Your Ref: OWPC4228
Our Ref: FP/186/14/HH 15-10-2014
Please ask for:
Mrs J Chapman

Demolish existing conservatory, rebuild side extension with pitched roof & single & two storey rear extensions.

15 Chesswood Avenue Bognor Regis

Roof Plan

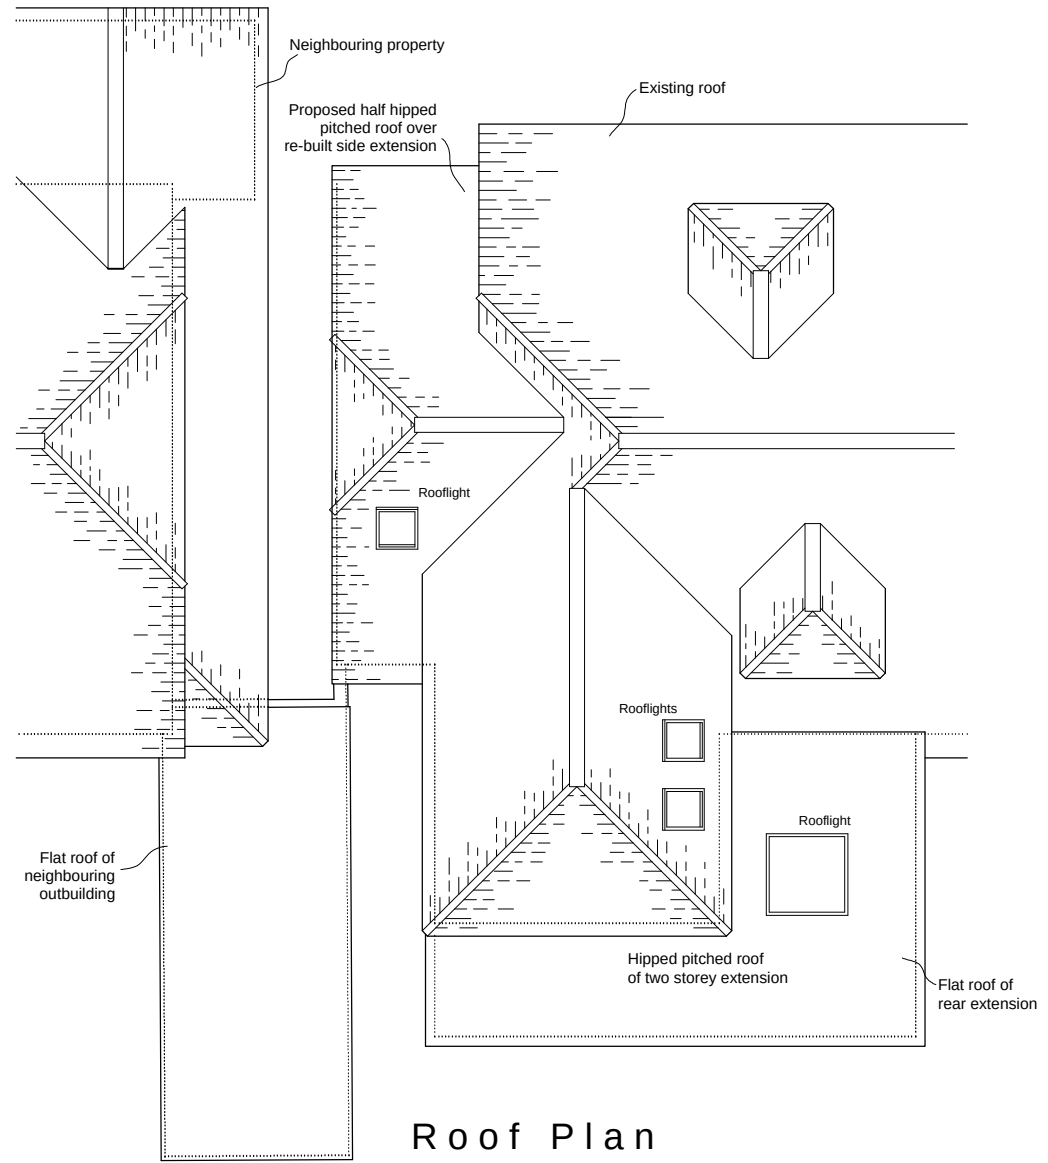
I do not object to the development in principle, but my concern is the Velux windows in the first floor extension on the South Elevation. This is because they would be overlooking my rear garden and I would like to maintain my privacy as much as possible and my personal preference is for them to be excluded.

South Elevation

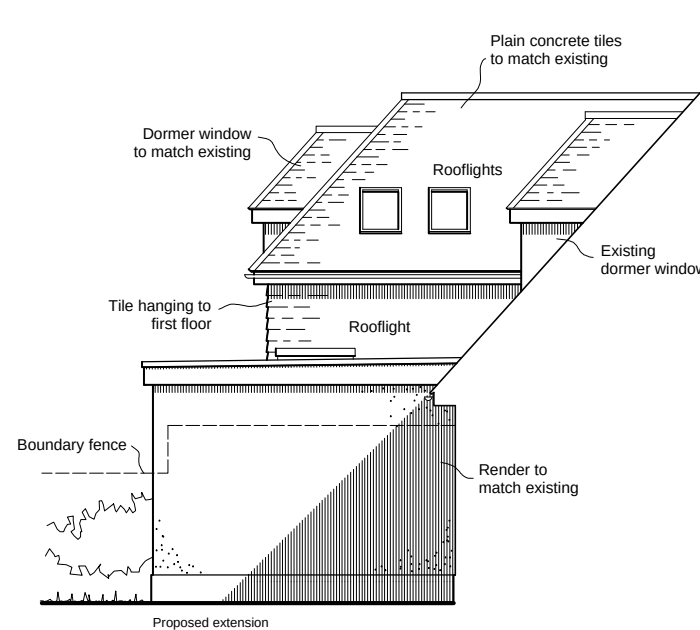
However, if considered essential by the applicant then as there is an openable, clear glass window to bedroom one on the West Elevation, I would like to request that the approval then includes a condition to ensure the proposed Velux windows should be either set higher than 1.7m from first floor level or fixed closed with obscure glazing.
